WEST SUSSEX COUNTY COUNCIL CONSULTATION

TO:	Arun District Council FAO:
FROM:	WSSC - Highways Authority
DATE:	27 March 2019
LOCATION:	Land west of New Barn Lane Bersted Bognor Regis
SUBJECT:	BE/37/19/PL & BE/29/19 Erection of 99 No. dwellings together with landscaping, open space & associated works. Access to be taken from New Barn Lane (alternative scheme to BE/29/19/PL).
DATE OF SITE VISIT:	20th March 2019
RECOMMENDATION:	No Objection
S106 CONTRIBUTION TOTAL:

TYPICAL SECTION THROUGH 2.0m POS FOOTPATH
Scale 1:20

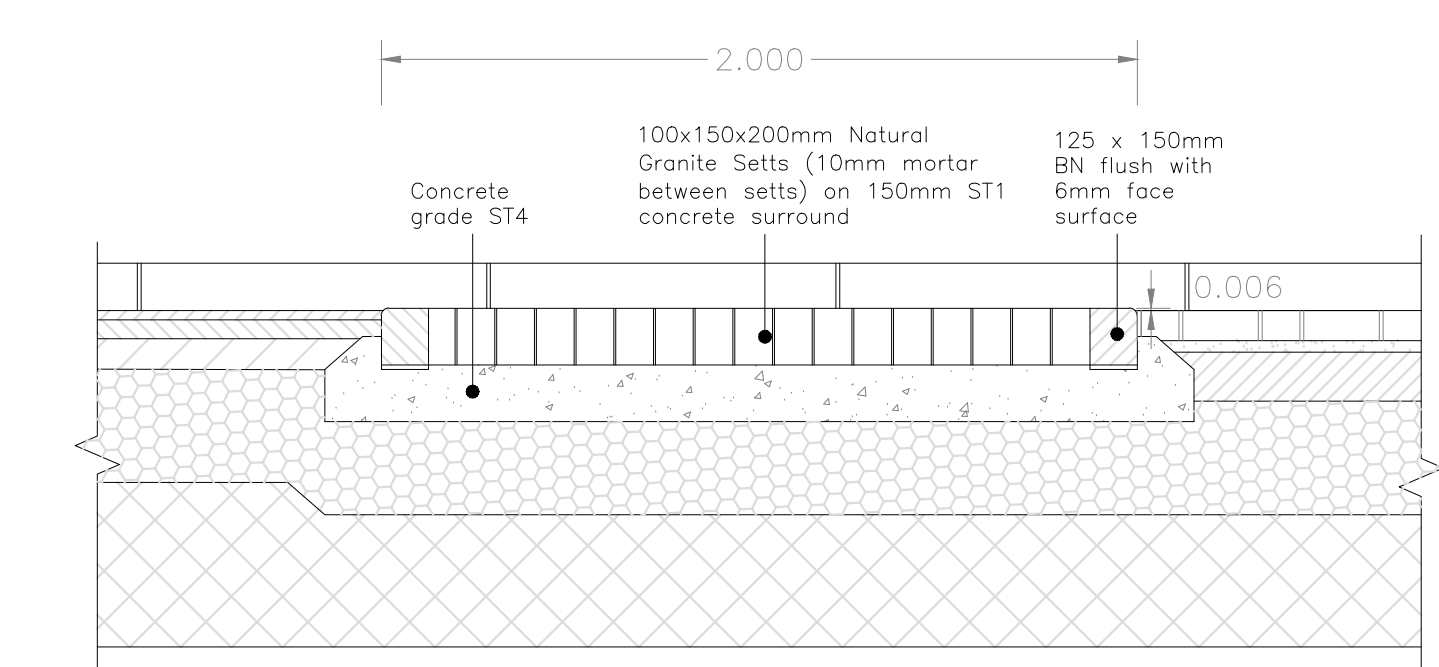
The footpath within the site linking the two playing areas should be 2m in width to encourage multiple uses as per guidance in inclusive mobility for an ambulant person and wheelchair user to comfortably use the routes together. WSCC would also recommend these footpaths, link into the footway on New Barn Lane, providing a surfaced route out of the development with tactile paving and dropped kerbs. This should follow any natural desire line a person would take if travelling from the northern or central part of the site wishing to walk/use their wheelchair or cycle to the amenities found on the B2259.

scheme: Land West of New Barn Lane,
North Bersted, 'Alternative
Application'
client: Linden Homes
drawing: Soft Landscape Proposals
date: February 2019
scale: 1:200@A1
drawing no: LIN22349 11E Sheet 3
drawn: JO checked: DKM

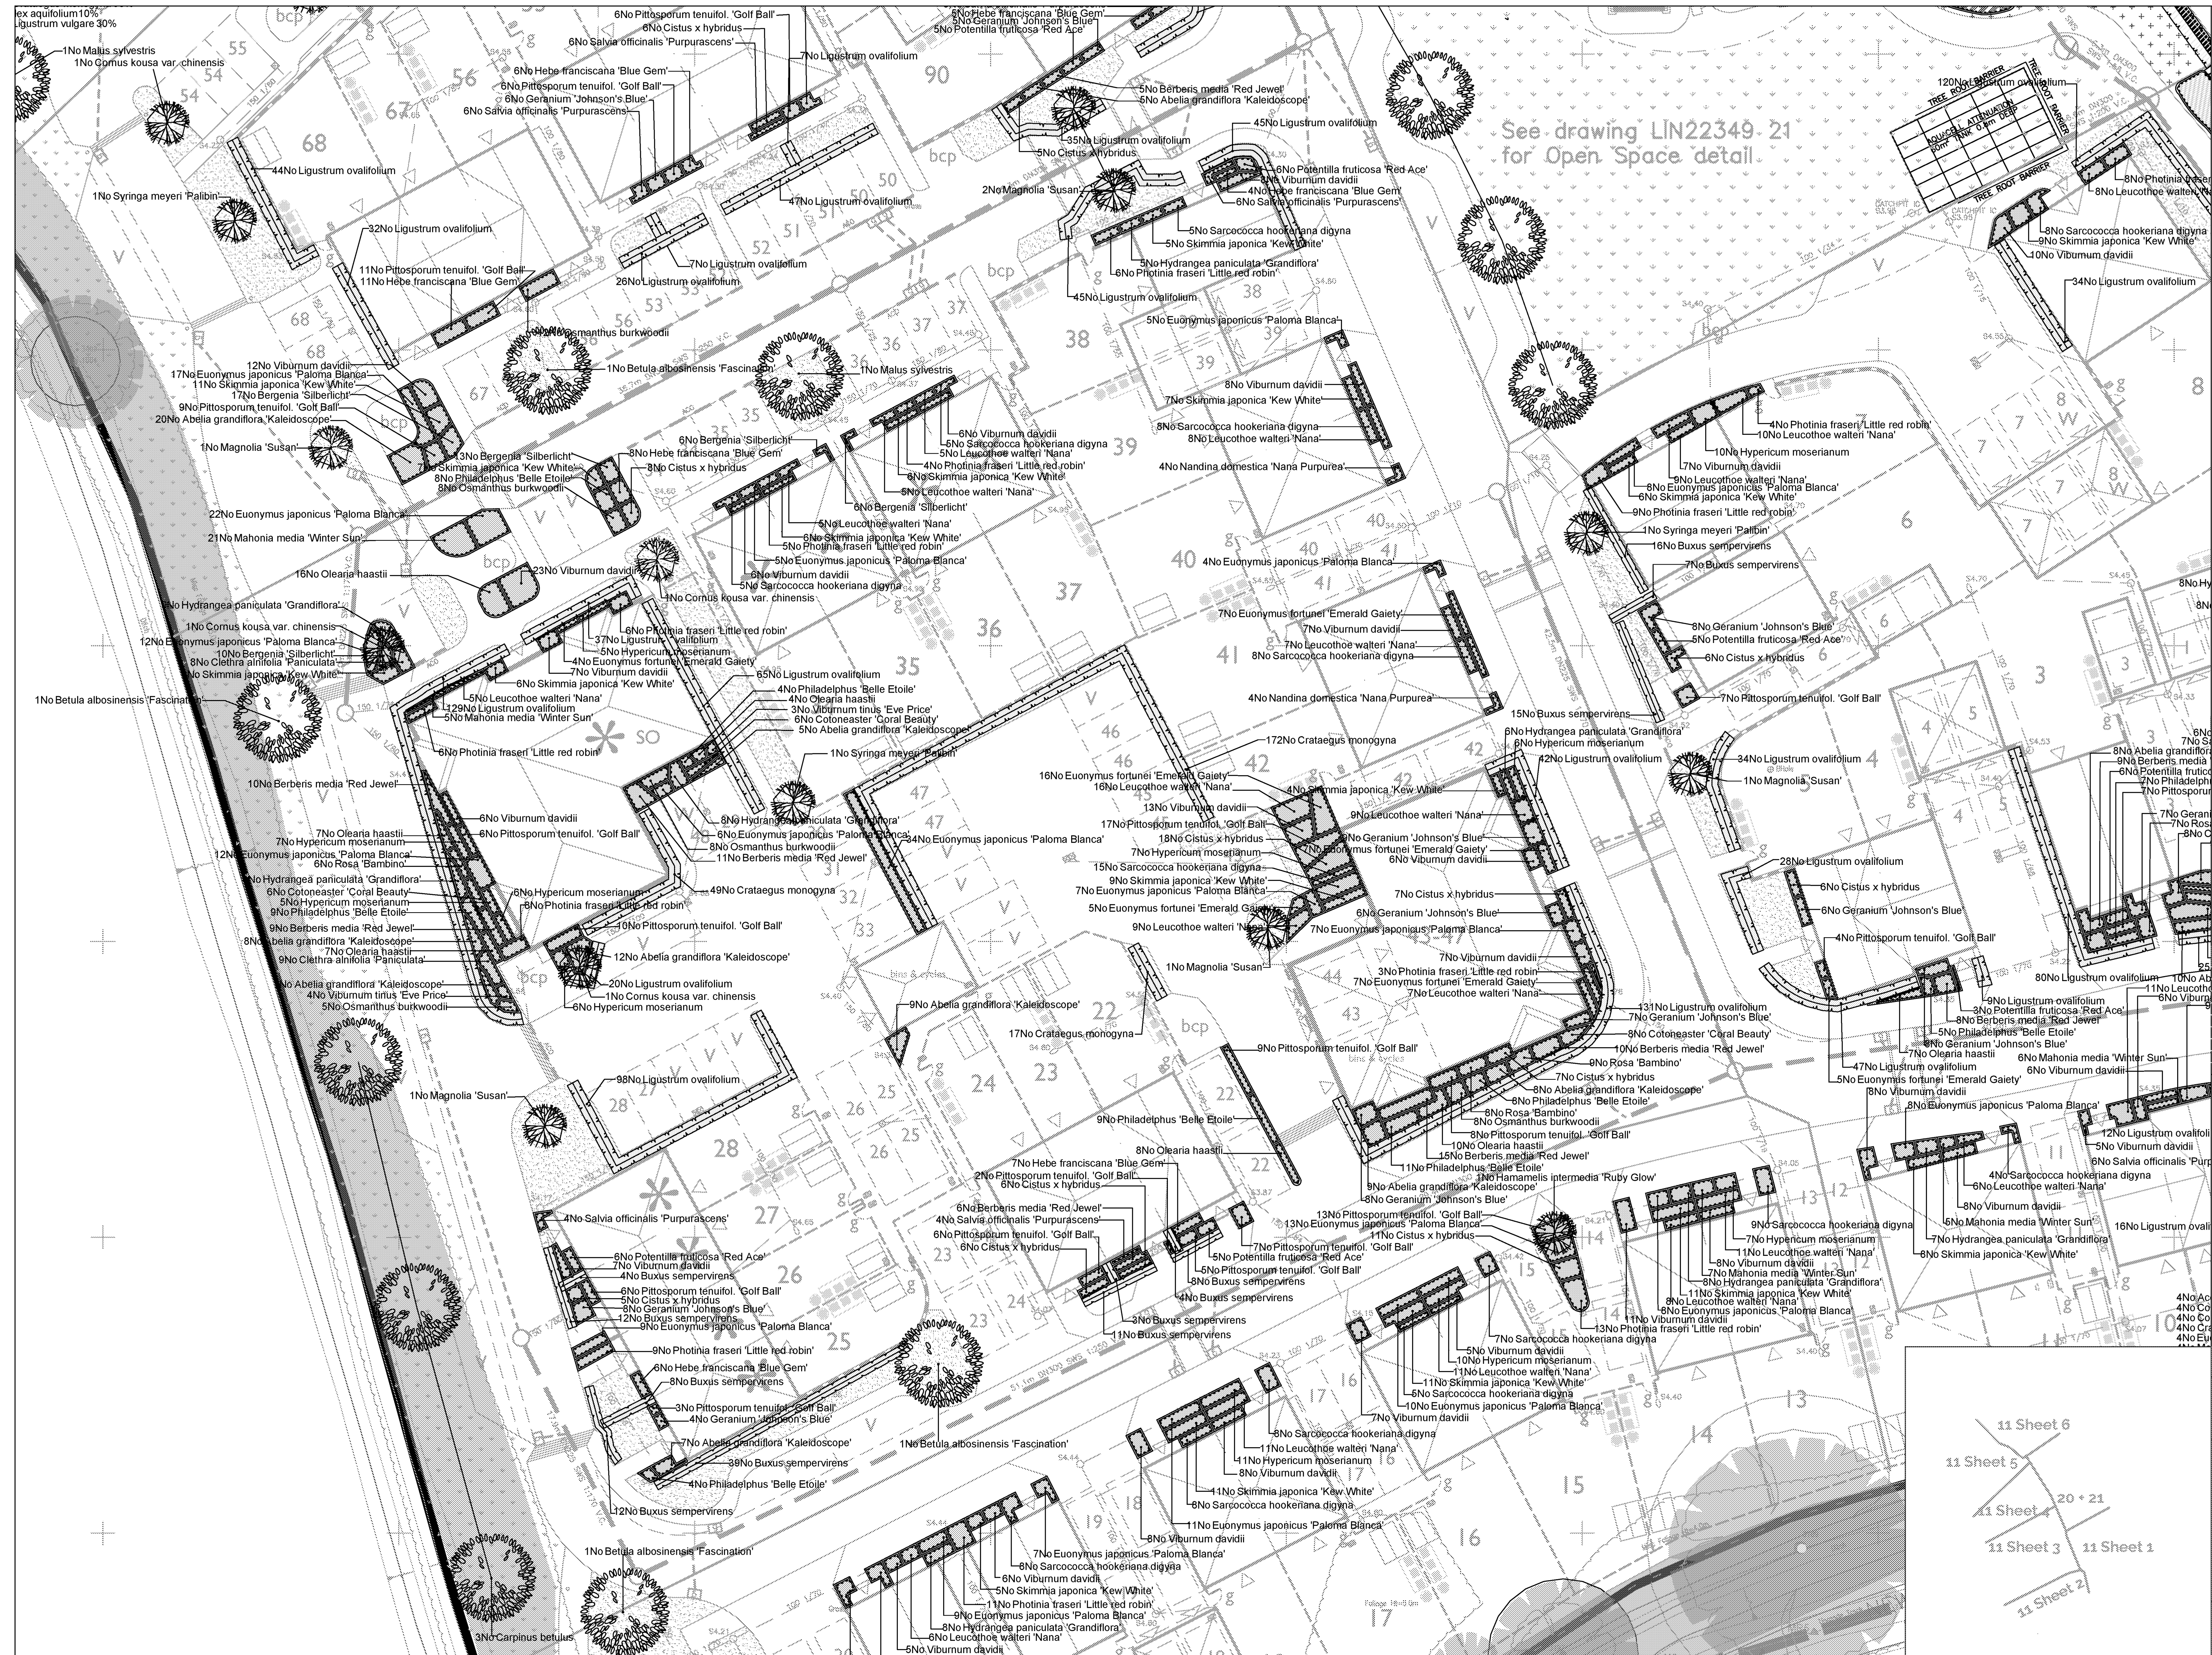
The changes for both applications provide an echelon car parking layout, interspersed with planting which should be below 0.6m in height, or if trees are planted these should only partially obscure visibility. There are also two tandem parking spaces for plots 71 and 82 which are acceptable as they will be used by the same dwelling.
